# CITY OF ALBUQUERQUE

July 19, 2019

**Re: 913 Silver SE**  
**Lot 19, 913 Silver Ave SW Albuquerque NM 87102**  
**Traffic Circulation Layout**  
Engineer's/Architect's Stamp 07-11-2019 (K14D118)

C-201

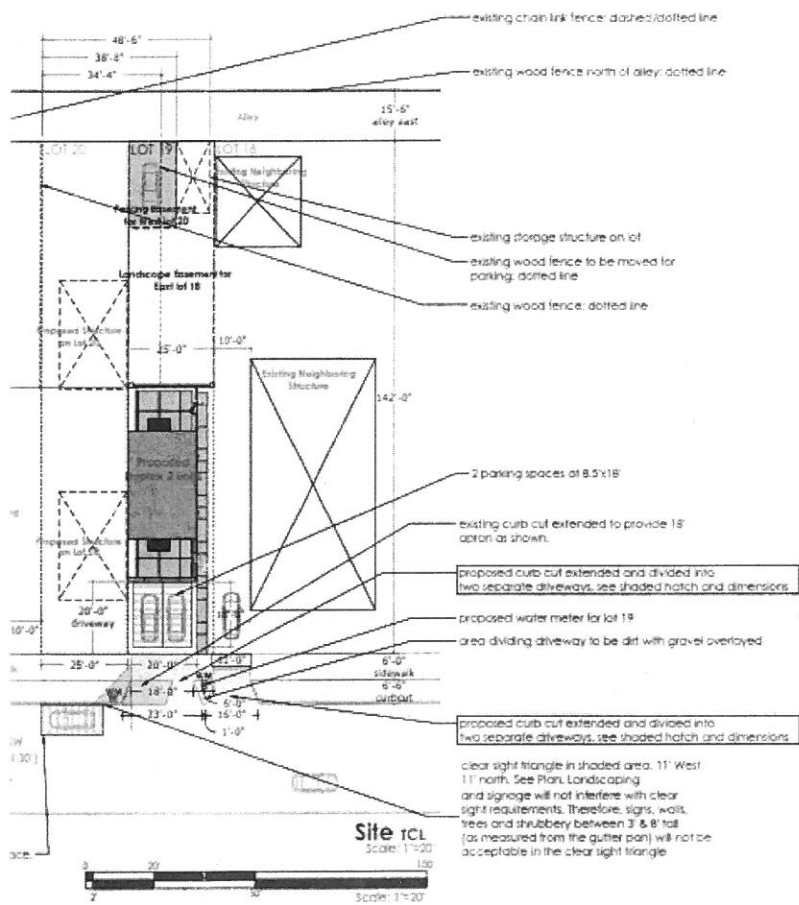
1. Please show a vicinity map showing the location of the development in relation to streets and well known landmarks.
2. List the number of parking spaces required by the zoning code as well as the proposed number of parking spaces including bicycle and motorcycle parking.
3. Per the Development Process Manual, Chapter 27 Drafting Standards, "Standard sheets must be 24" by 36" having a margin of 2' along the left and 1" on the top and bottom".
4. The scale must be shown on the plan. Per the Development Process Manual, Chapter 27, Section 2, Part B.1, on the following scales may be used:

$1" = 20'$   
 $1" = 40'$                        $1" = 50'$   
 $1" = 100'$  (for overall layouts only)
5. Show the clear sight triangle and add the following note to the plan: "Landscaping and signage will not interfere with clear sight requirements. Therefore, signs, walls, trees, and shrubbery between 3 and 8 feet tall (as measured from the gutter pan) will not be acceptable in the clear sight triangle.
6. Two measurement is shown for the existing curb cut. Please show the correct one.
7. The width of the drive allowed is 12 -22 ft.
